**From:** [REDACTED]  
**To:** [Norfolk Boreas](#)  
**Cc:** [REDACTED]  
**Subject:** HHPC response for 20th August deadline  
**Date:** 17 August 2021 06:39:01  
**Attachments:** [17F4143B566A44658FAAC969683FB22E.png](#)

## 8.27 Onshore Project Substation Masterplan

F&OBO Holme Hale Parish Council

Plate 8 Substation Footprint Options

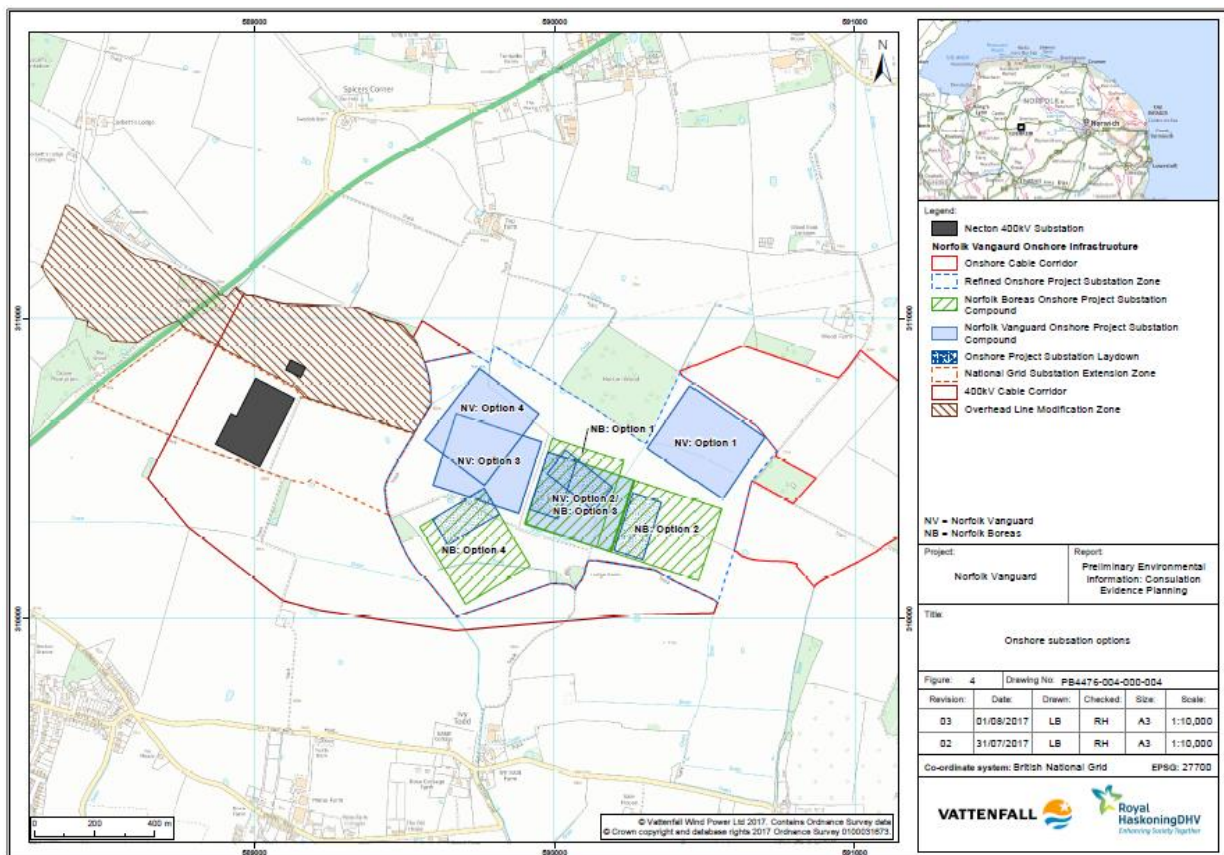
*"Zoning of the onshore project substation footprint to locate the convertor buildings in the northern zone of the onshore project substation footprints..."*

The Horlock rule notes of Section 3, subsection 7..note 6.. clearly requires the buildings to act as a screen from the outdoor switchgear, but with Necton Woods to the north of the substation, and the applicant's proposal to site the 19m tall convertor buildings to the north of the site, it means the switchgear will be completely unshielded from view for anyone looking towards the development from the south & south east.

There is no explanation to justify why they have gone against the Horlock Rule guidance, though a verbal response to a challenge to this decision, was that it was because the cables came in from that side.. We see no reason the cables could not continue underground to anywhere within the site, releasing the designers from that constraint.
